Re: Framing Issues
Location: Lot 38 Cambridge Reserve (46 Atherton Circle Angier, NC)
JDS Project No.: RDU2505145
Date of Inspection: 05/16/2025

A representative of JDS Consulting arrived on site to observe the issues reported to us by the client, which are presented, along with our recommendations, in this report.

**CRAWLSPACE SLAB FOUNDATION PLAN**  
SCALE: 3/16"=1'-0" ELEV. B

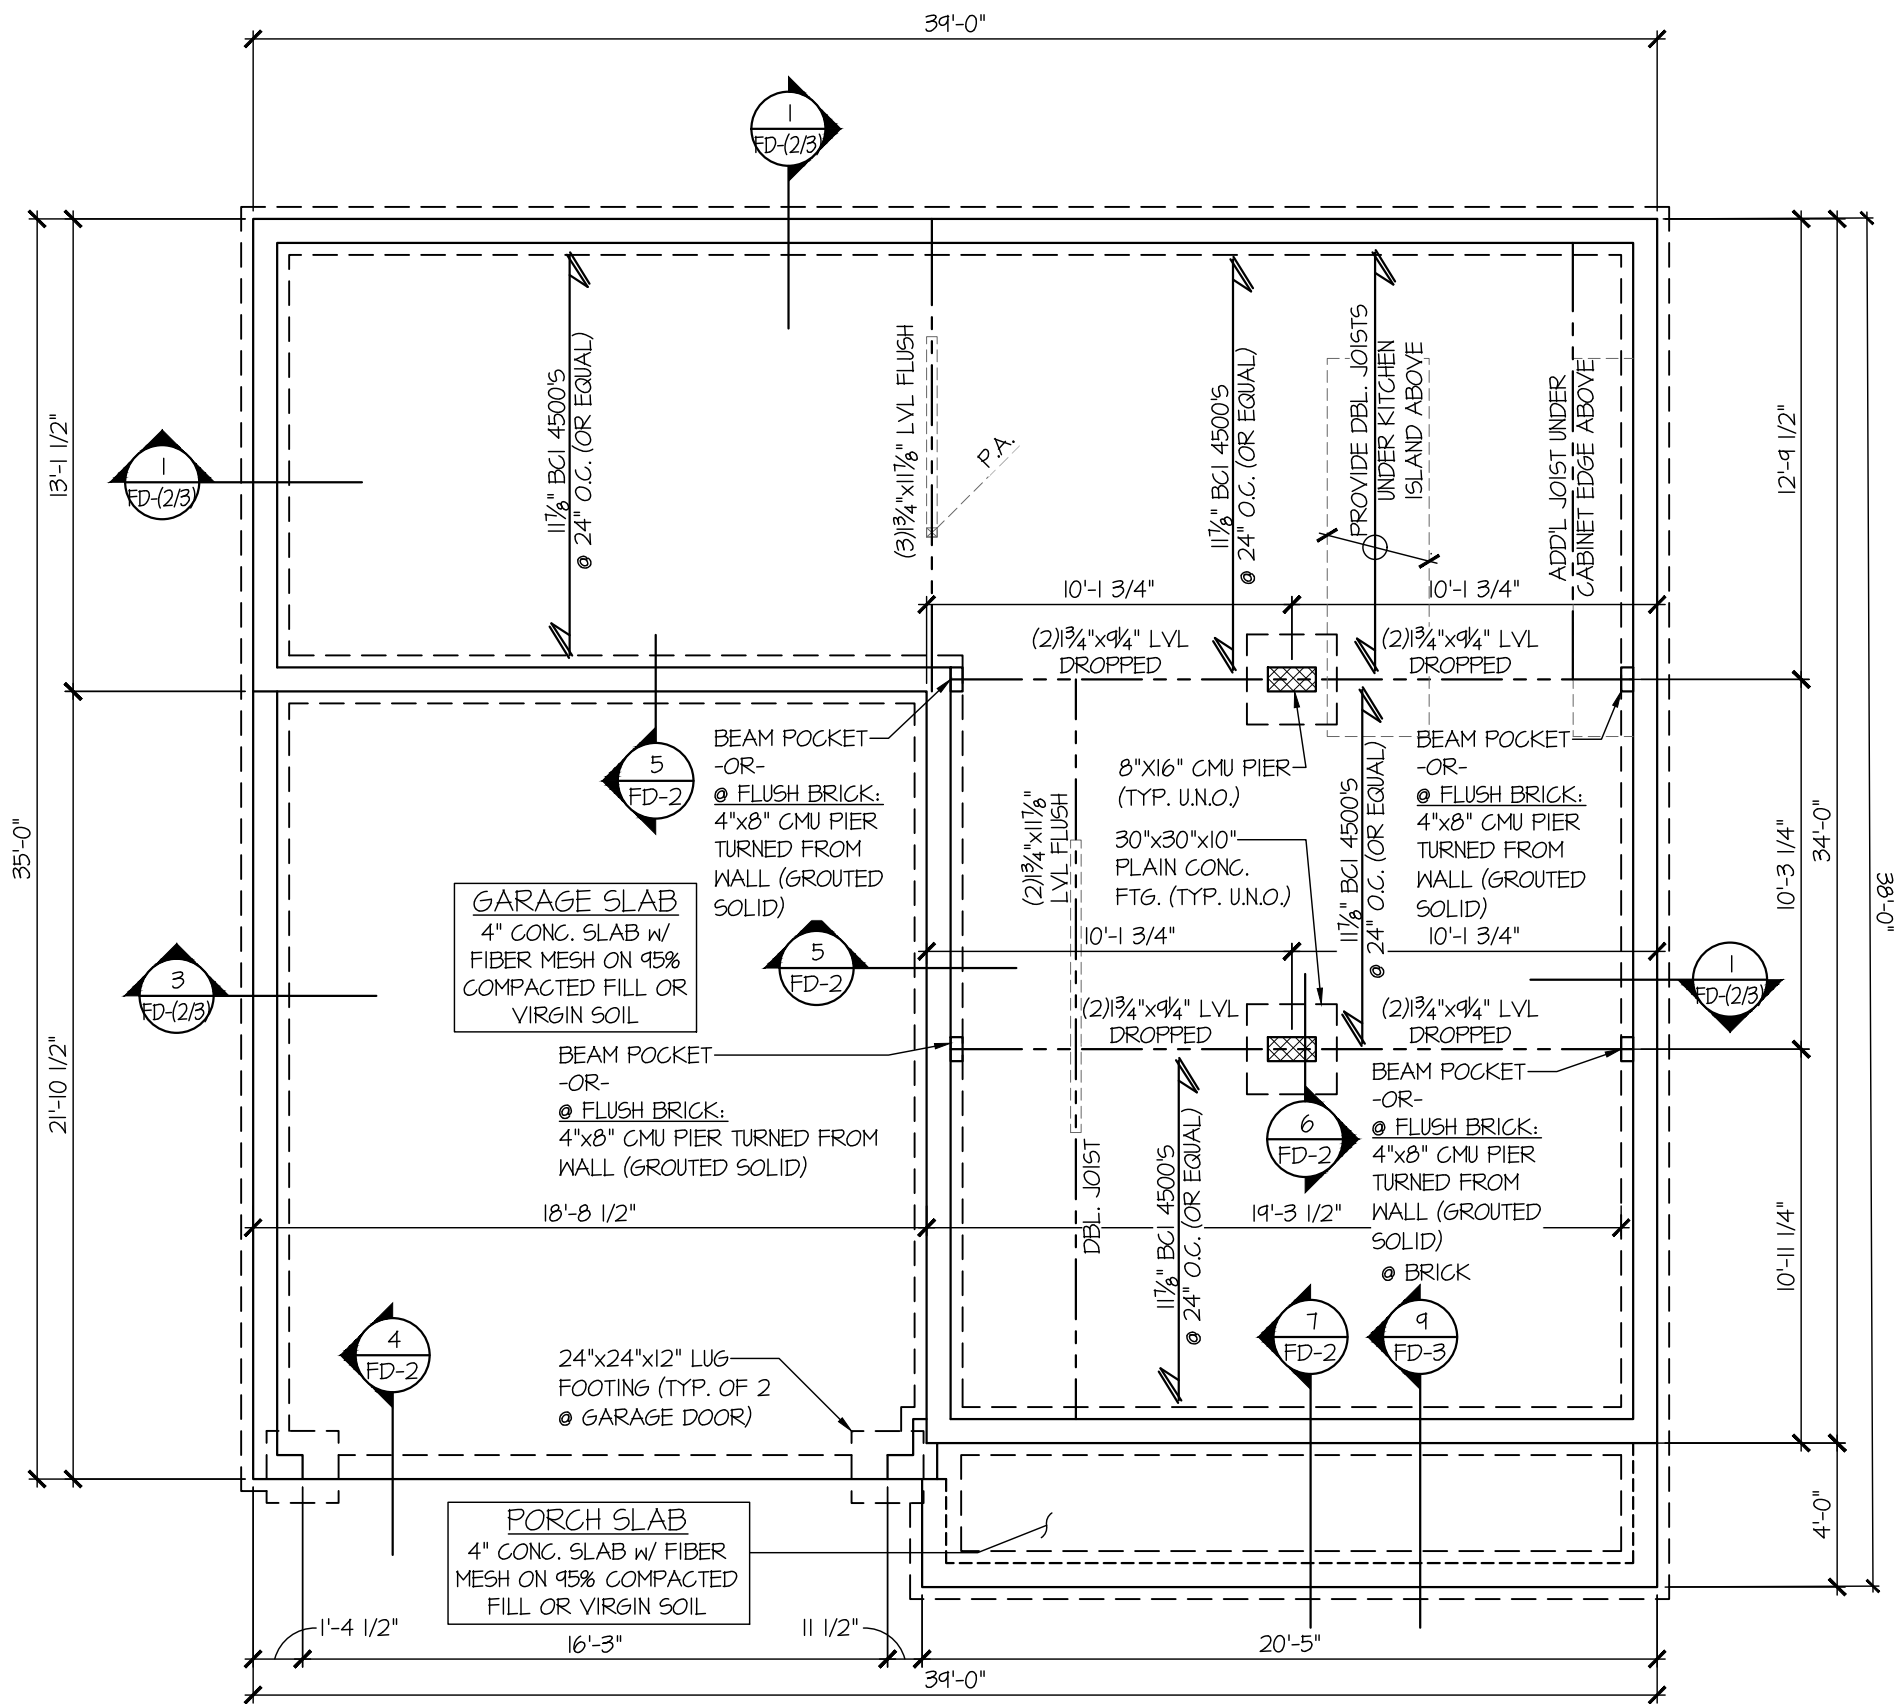
The client requested an evaluation of a bearing issue presented in a letter from the local inspector. The girders in the crawlspace are not fully supported along the width of the piers. Blocks have been installed on the top center of piers to provide contact.

Based on our observations and review, install full length pressure treated blocks under the girders for full support along the width of the piers.
